APPLICATION NO:	SSD-10432 (Our Ref. 25-2023-10-1)
PROPOSAL:	Stone Ridge Quarry Project
PROPERTY:	150 Italia Road, BALICKERA (LOT: 65 DP: 753200)

Thank you for your correspondence dated 16 June 2023 requesting Council's comments regarding the submitted Environmental Impact Statement (EIS) dated 25 May 2023, for the Stone Ridge Quarry Project, located at 150 Italia Road, Balickera.

**FIGURE 3.1**  
**Amended Conceptual Quarry Layout**

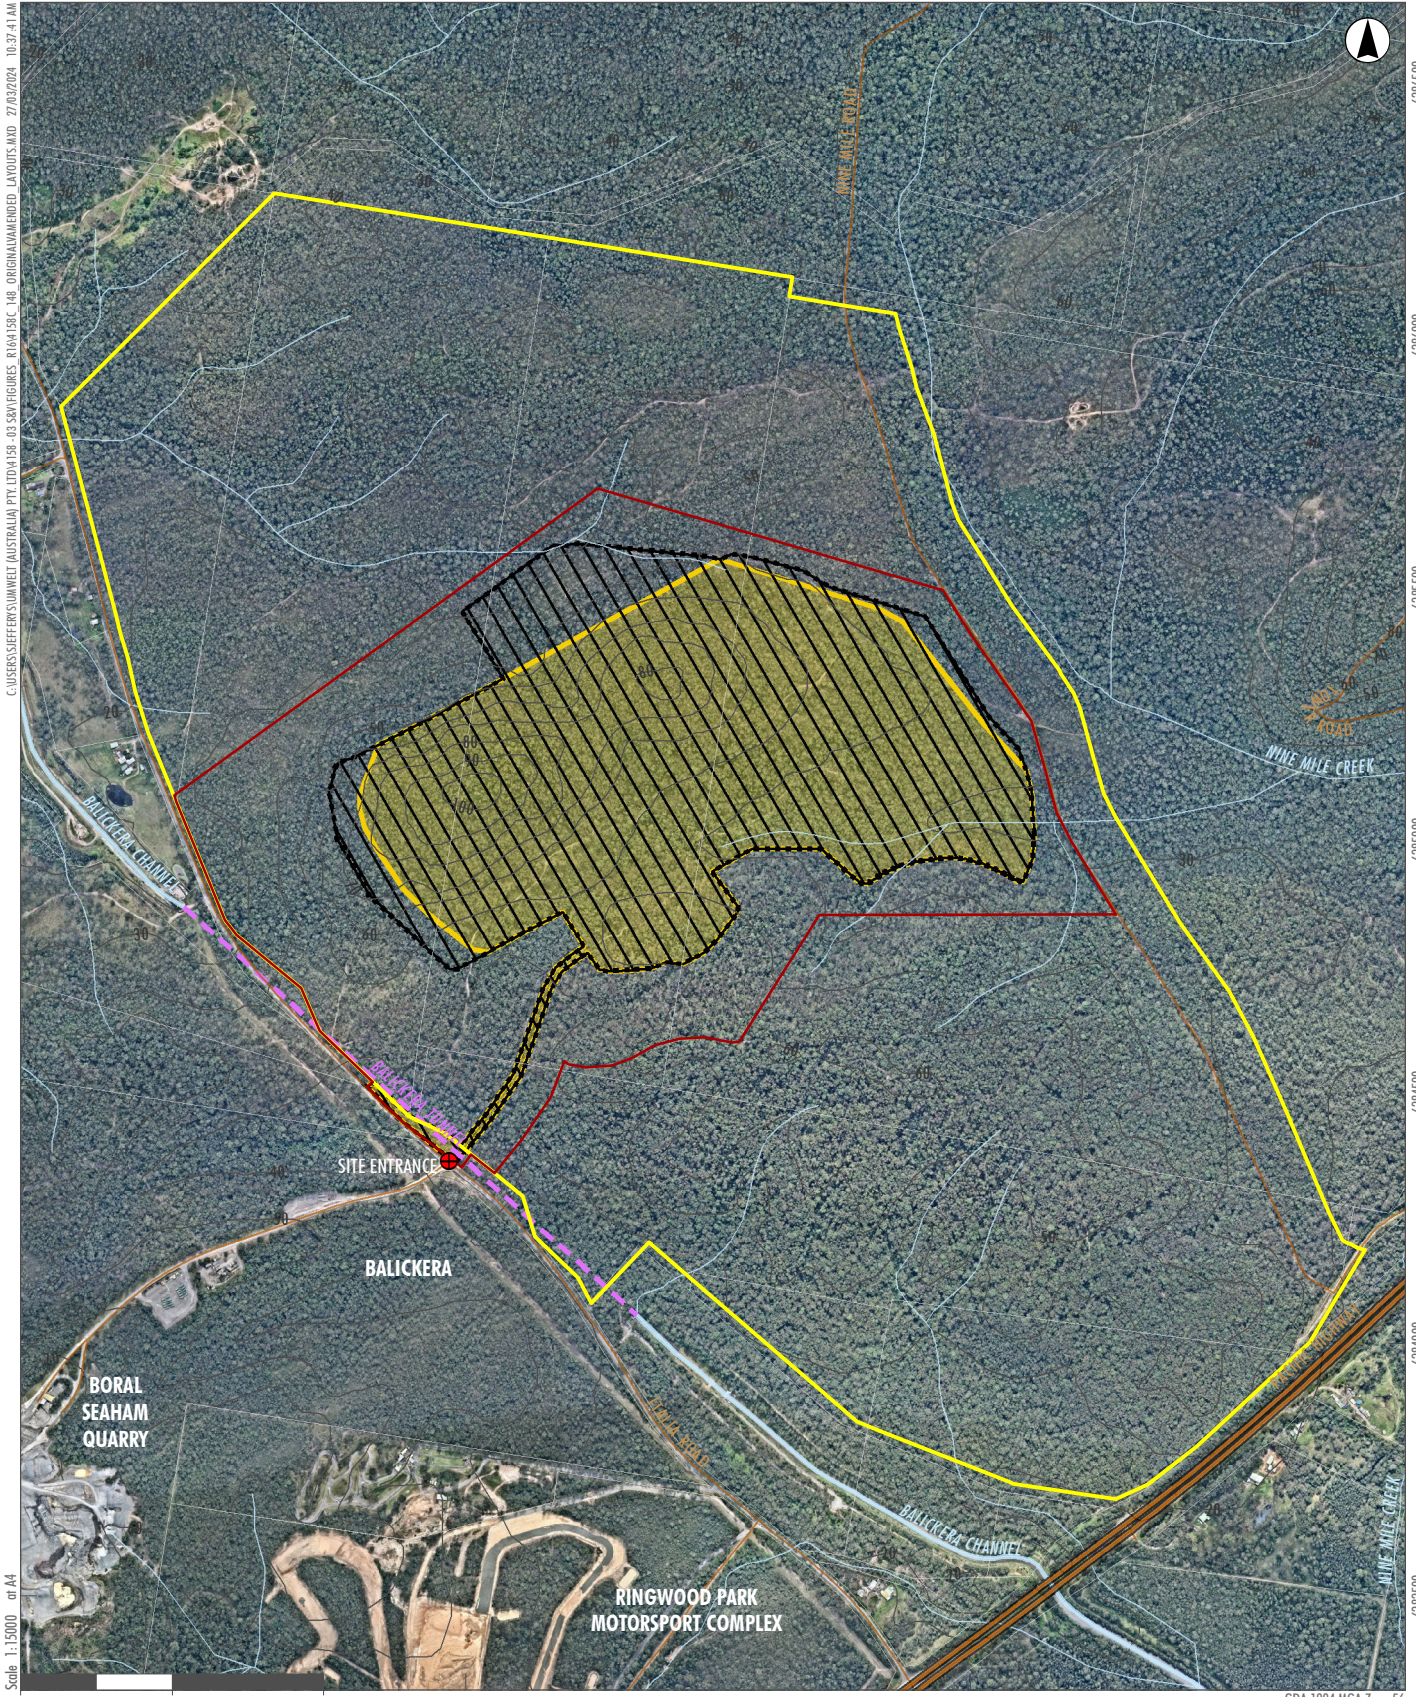
In accordance with the *Biodiversity Conservation Act 2016*, the *Biodiversity Conservation Regulation 2017* and the Biodiversity Offset Scheme (BOS), proponents must demonstrate that the hierarchy of avoid, minimise and then offset has been applied. The current project design currently does not demonstrate adequate application of the BC Act avoidance hierarchy. It is recommended that the project footprint be reduced in the northern pit area, Stages 6 – 9 and access road relocated, to avoid and minimise impacts on a number of high biodiversity values including:

The below figure shows an indicative reduced footprint based on Council's interpretation of how the BC Act avoidance hierarchy should be applied.

Recommended reduced project footprint and access road relocation indicated in bold red outline

considered serious and irreversible. The potential vibratory impacts associated with proposed stages 6 - 9 of the project are highly unpredictable and lack scientific certainty. Consequently, the precautionary principle must be applied and potential impacts assessed in detail, or the project footprint reduced to avoid impacts (remove stages 6 - 9).

Removing stages 6 – 9 from the project is recommended to ensure that impacts associated with groundwater drawdown and groundwater dependent ecosystems is avoided. The area of likely groundwater drawdown is extensive, as shown on Figure 4.4 of the BDAR, and will impact vegetation, habitat quality and the species that rely on these habitats. The BDAR states that there is an additional 82.88 ha of vegetation that forms potential Groundwater Dependent Ecosystems within the modelled groundwater drawdown impact area. It is predicted that groundwater drawdown will modify vegetation types towards more dry adapted species as stated in the EIS:
